Date: 16-Sep-2022
Our Ref: 2022/92666

**TOWN AND COUNTRY PLANNING ACT 1990
TOWN AND COUNTRY PLANNING (GENERAL PERMITTED DEVELOPMENT) (ENGLAND)
ORDER 2015 – SCHEDULE 2, PART 1, CLASS A.1 (g)
AT: 34, Foster Avenue, Crosland Moor, Huddersfield, HD4 5LN
Prior notification for single storey rear extension**

The Authority has considered your application and it has been determined that the proposal is not acceptable and prior approval is hereby **Refused** for the following reason(s);

Fig 3. – Block Plan

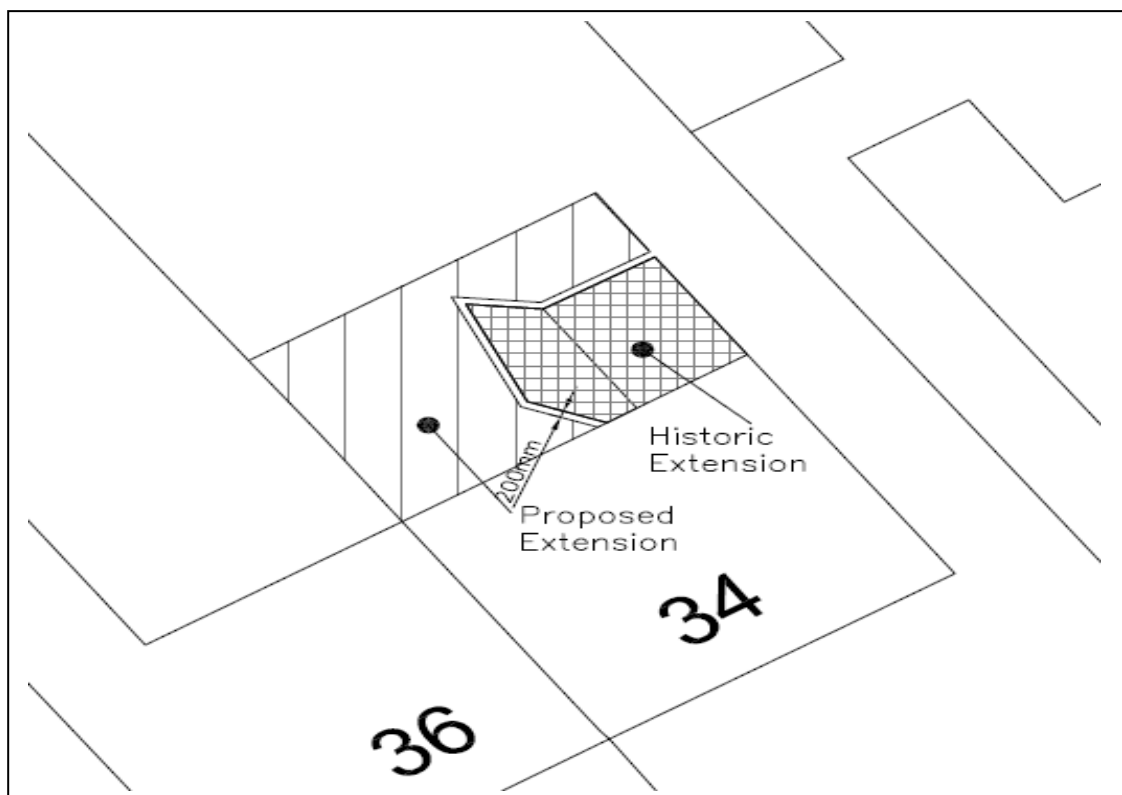
The proposed enlargement projects beyond a side wall of the original dwellinghouse and is more than half the width of the original dwellinghouse, thus contrary to sub-paragraph (j) of Part 1, Class A of Schedule 2 of the Town and Country Planning (General Permitted Development)(England) Order 2015 (as amended).
